CITY OF ALBUQUERQUE

Re: L&C Transport 8705 Central Ave NW
Request for 120 Day Temporary C.O. - Accepted
Engineer's Stamp dated: 06-14-13 (K09/D037)
Certification dated: 2-03-14

GRADING AND DRAINAGE PLAN
Sheet Title
Checked By: E.S.
Drawn By: H. Hoad & B. J. Montoya

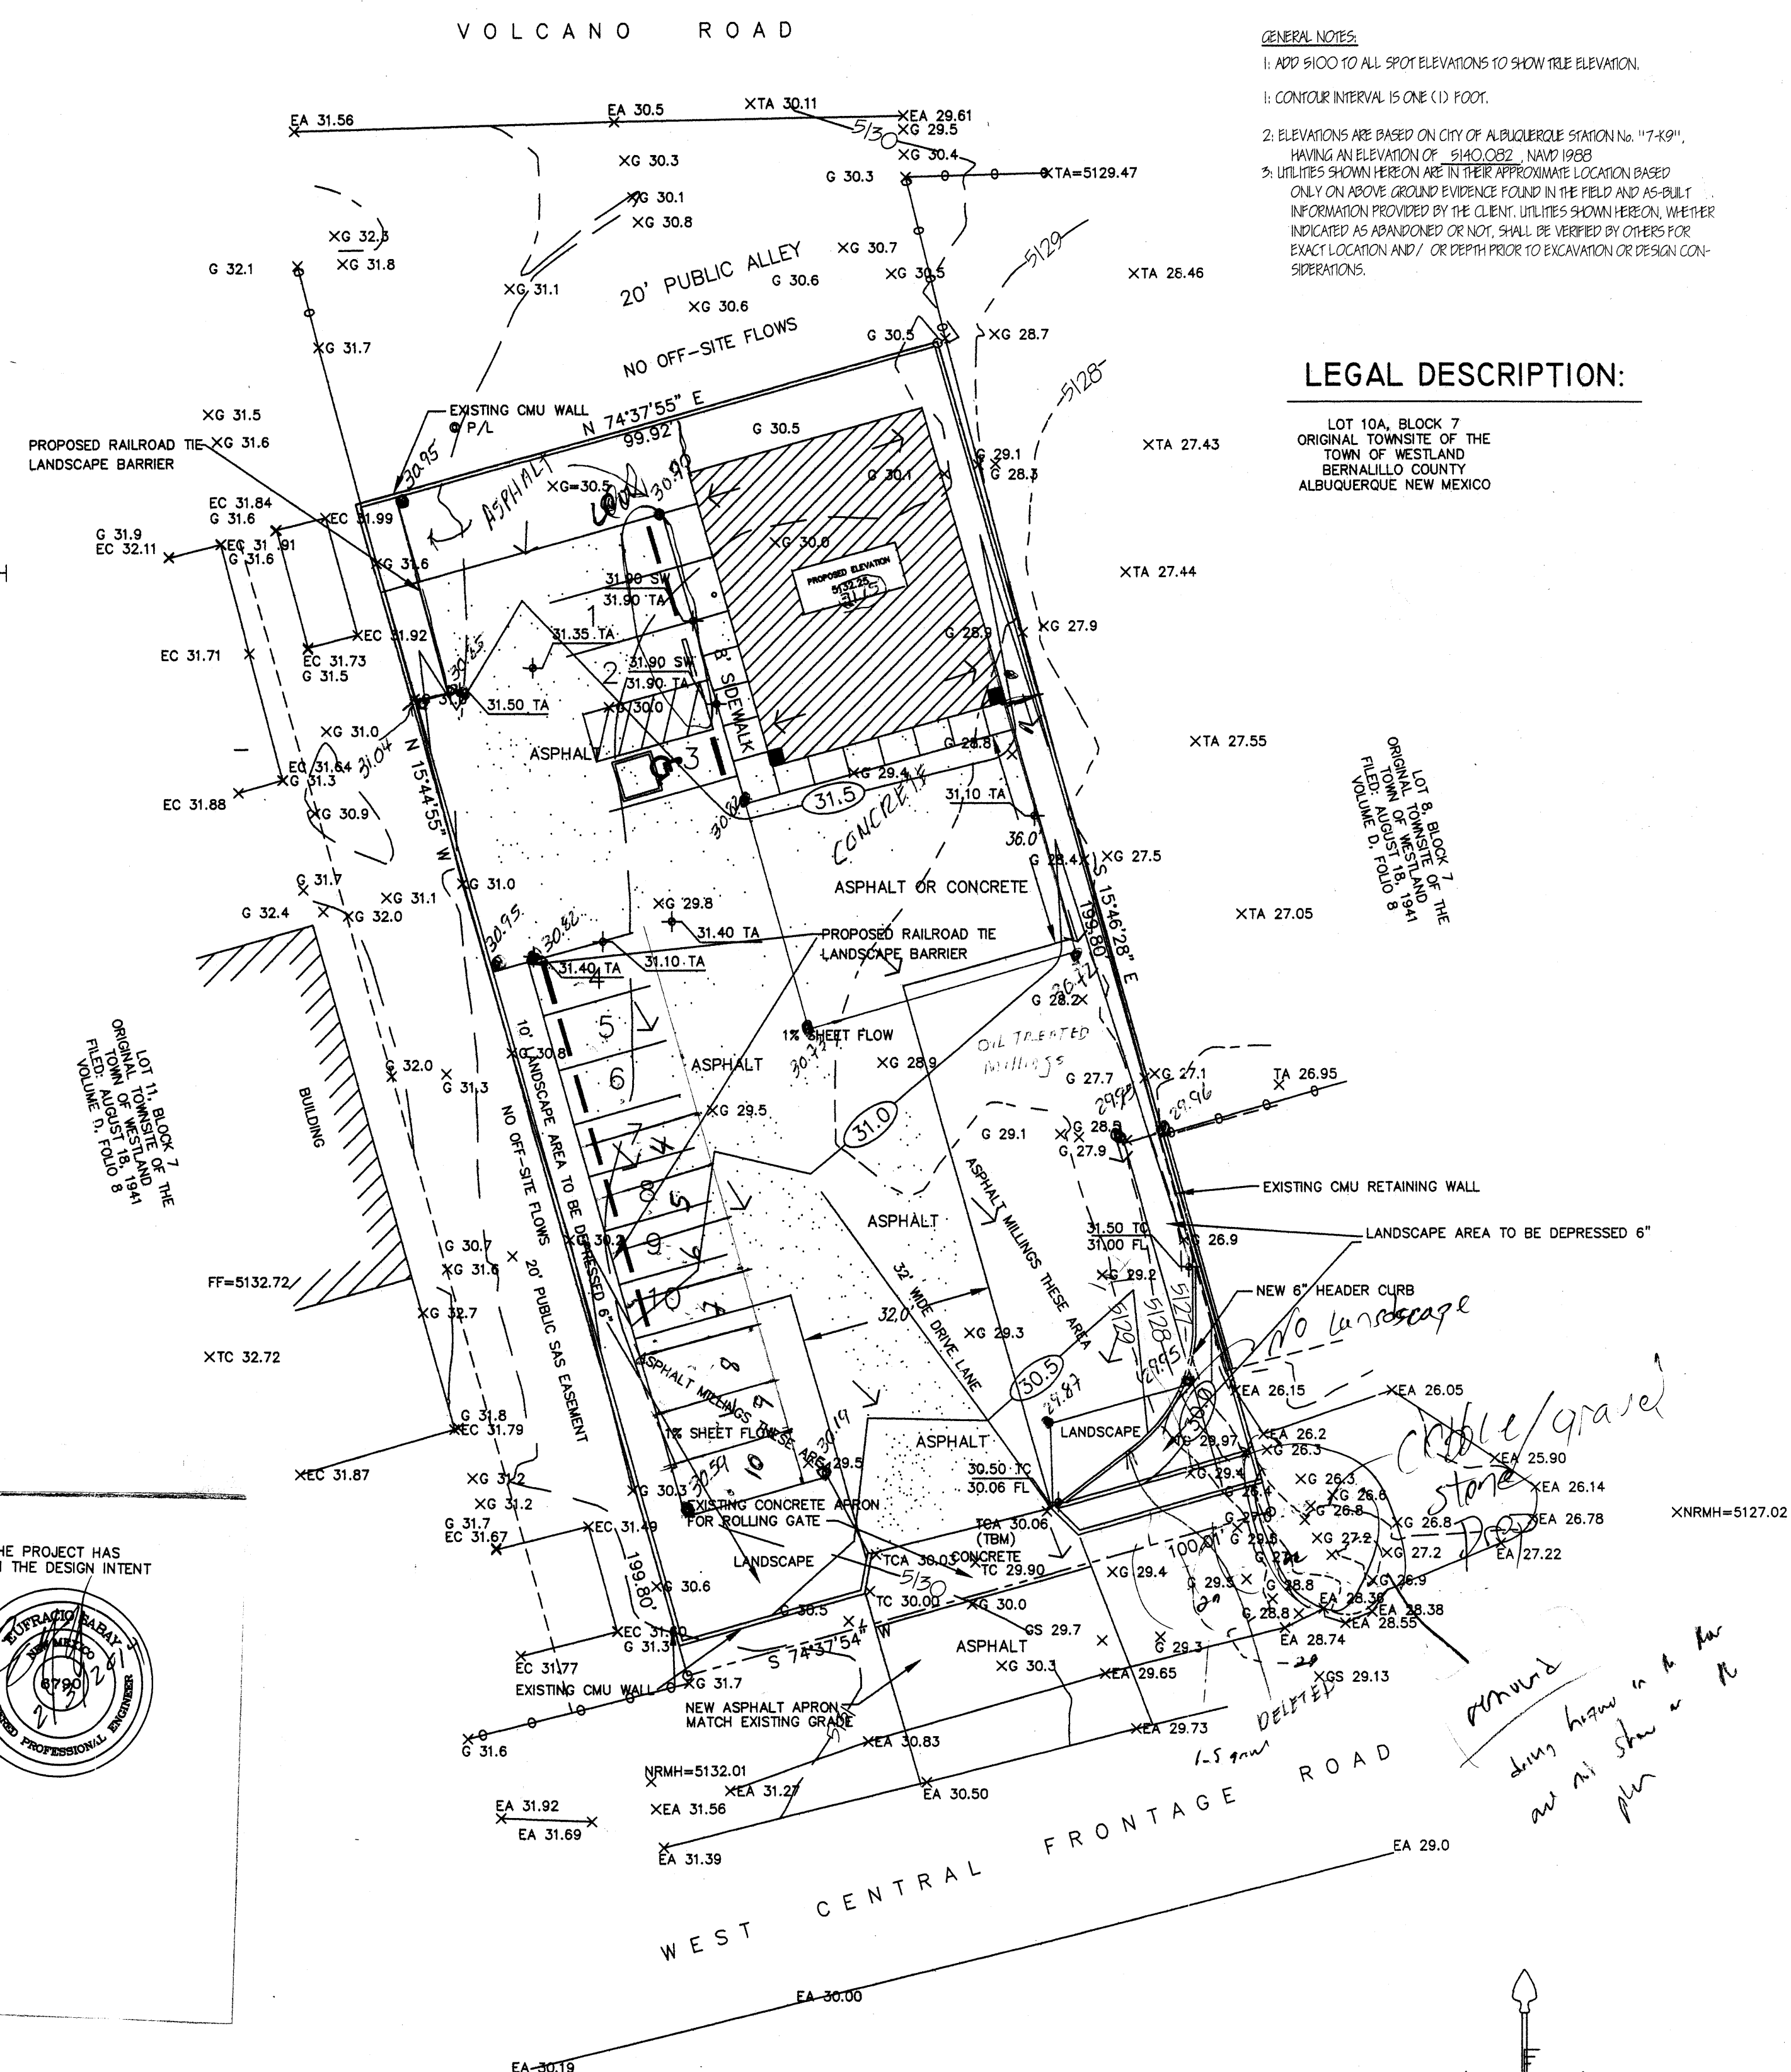
- The public right of way is not acceptable as is. Replace the cobble stone with 1" to 1.5" gravel at a slope which is passable by a vehicle and does not cause erosion.
- A gutter system needs to be placed on the west side of the building so that roof flows are directed away from the building.
